# PORTLAND MAINE

November 24, 2009

Re: 150 Riverside Street – 267 A006 – B-4 – freestanding sign – Permit #09-1315

Project: UPSCALE comp. 1

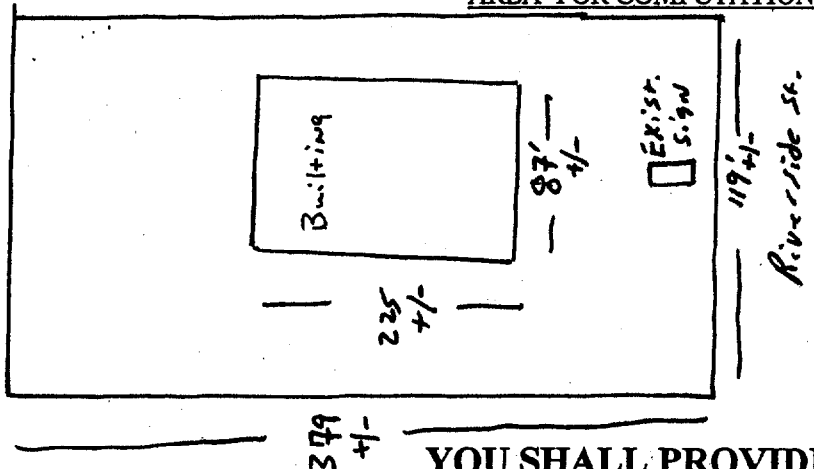
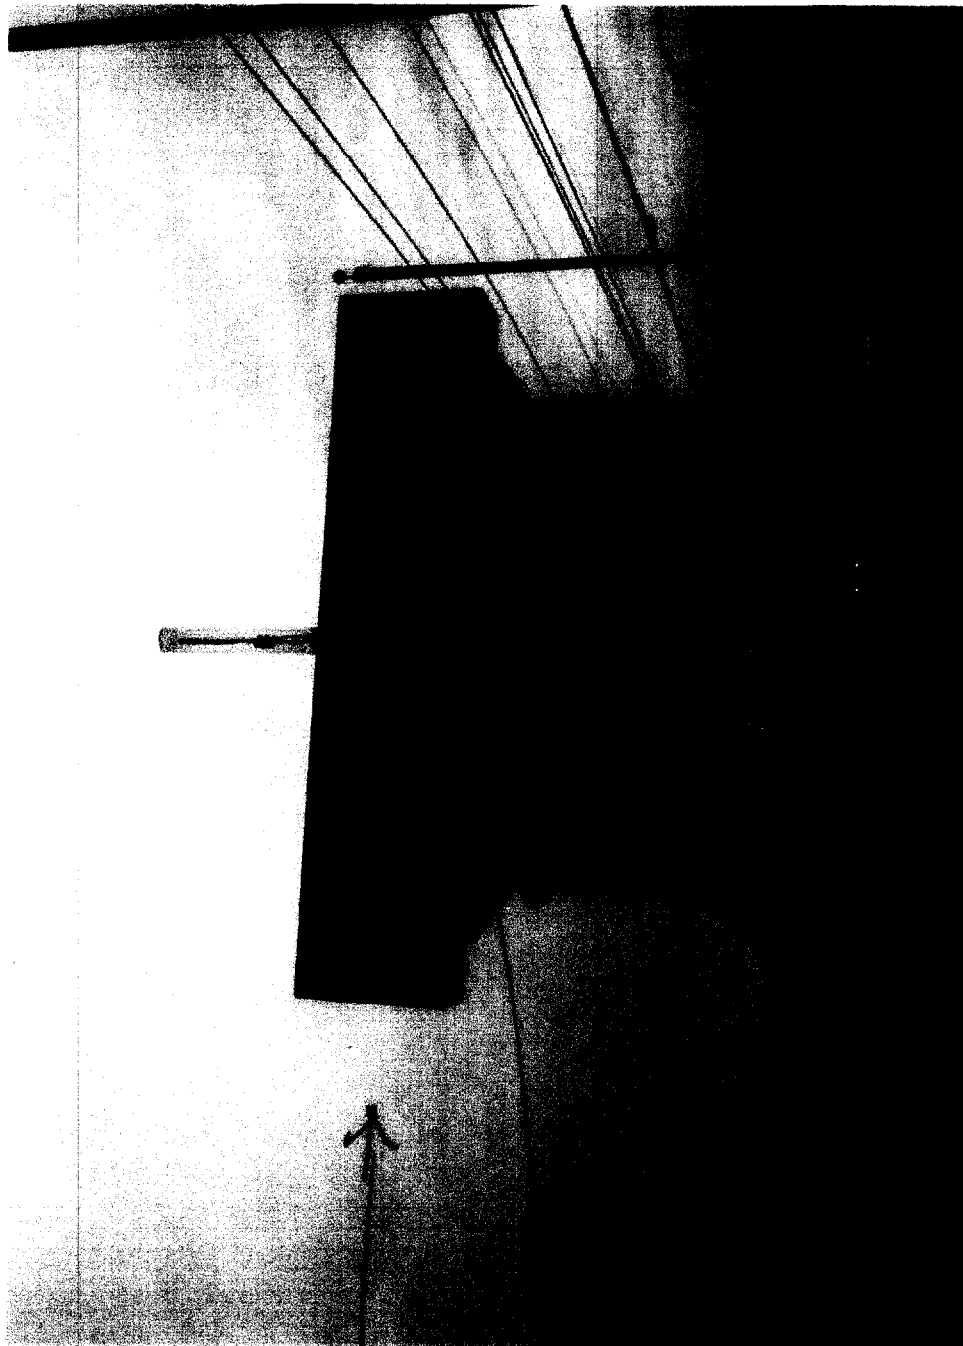
In researching the previous permits, there was a permit issued in 2002 (#02-1245) to change the sign from Verizon to Upscale. On that permit there was a 30" by 12' panel, an 8" x 84" panel and an 84" by 40" panel. The total square footage added up to 56.89 square feet. After this permit was issued, the bottom 30" x 84" panel was added without a permit. Since this bottom panel was added without a permit, it is not legal, and it has made the sign nonconforming. The bottom panel must be removed to bring the sign into compliance.

12.07.2009

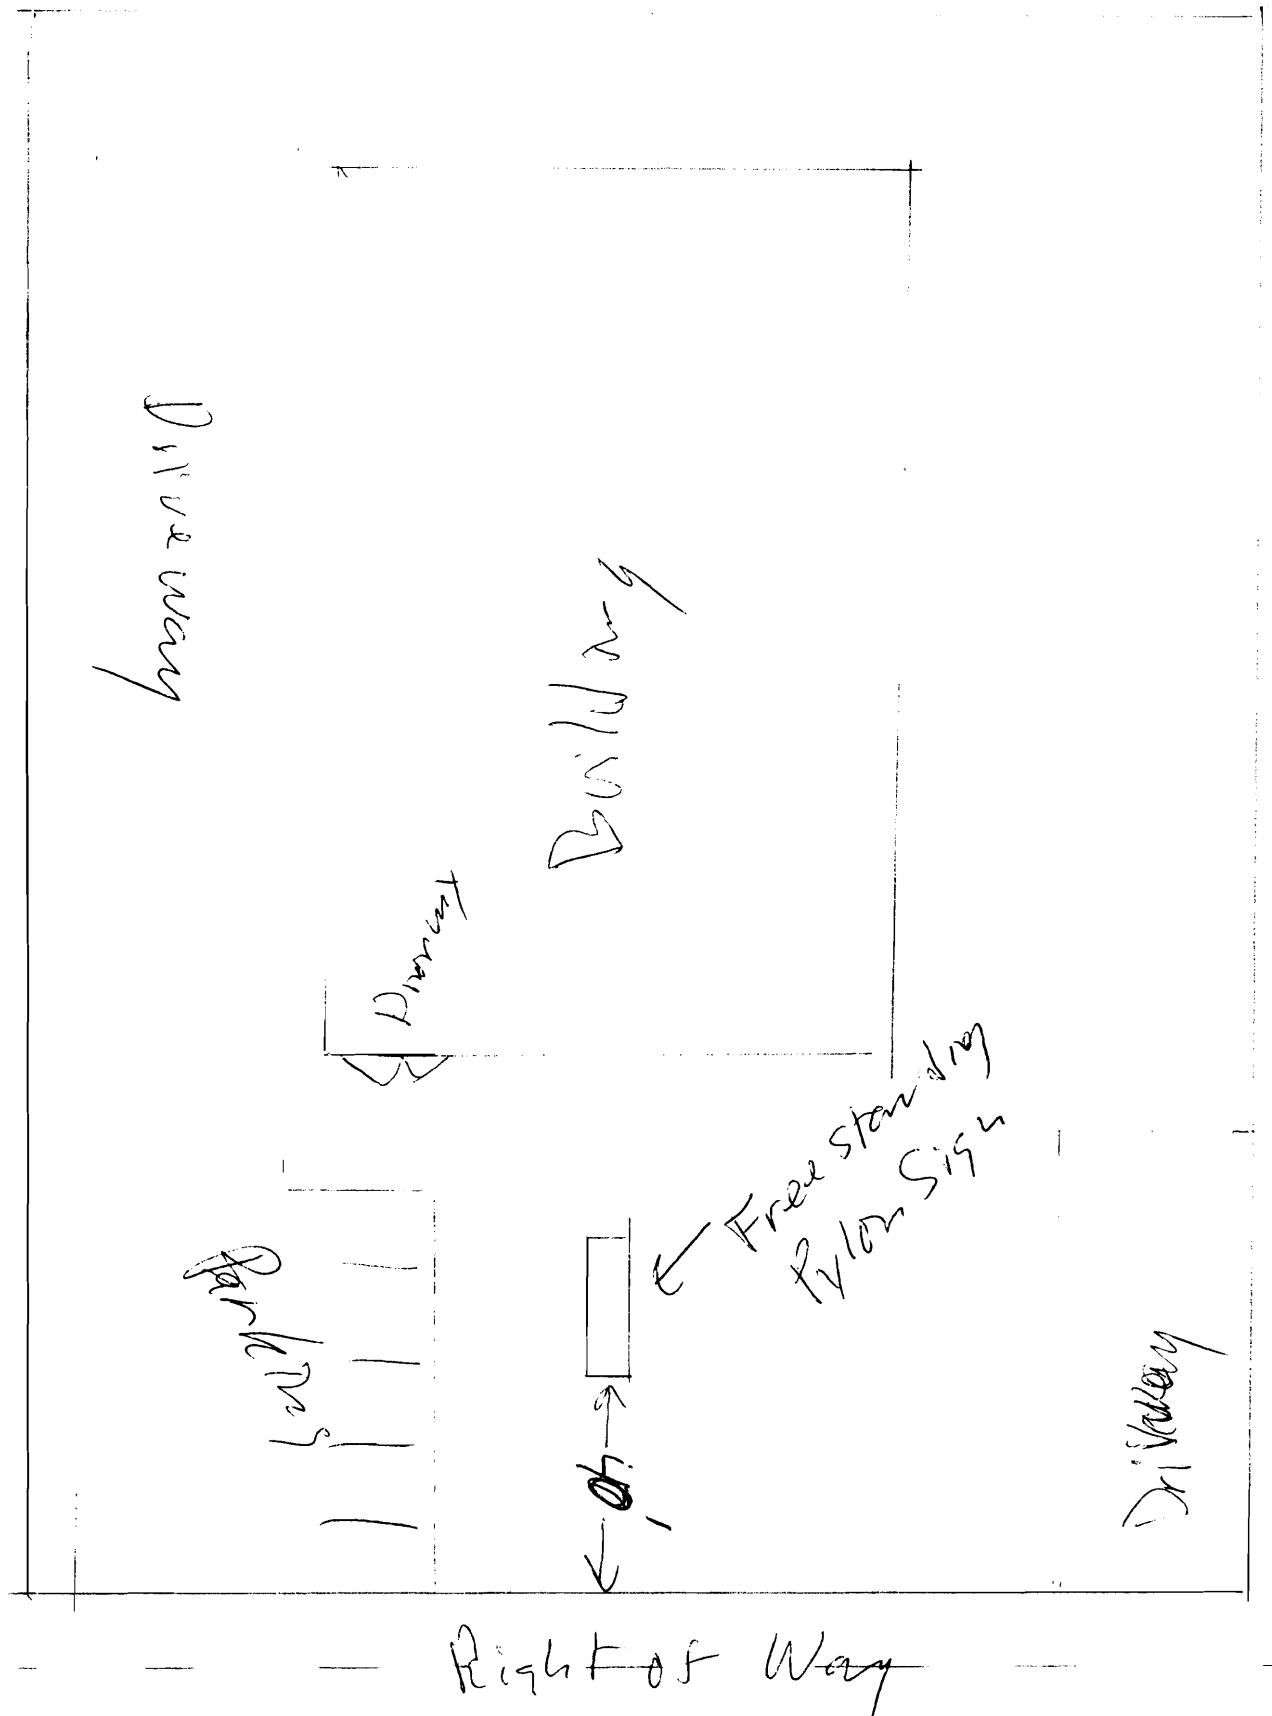
In reviewing the sign permit application to replace an existing sign cabinet on the freestanding sign at 150 Riverside Street, I had to check the maximum square footage of all the sign panels. The total square footage for the existing signs adds up to 74.76 square feet. In the B-4 zone, the maximum square footage allowed on a freestanding sign for a single tenant lot with street frontage of less than two hundred feet is sixty-five square feet (section 14-369.5, Table 2.10), so the existing freestanding sign exceeds the maximum allowable square footage.

Until the sign is brought into compliance, a permit cannot be issued to change the 40" by 84" panel to an electronic message center.
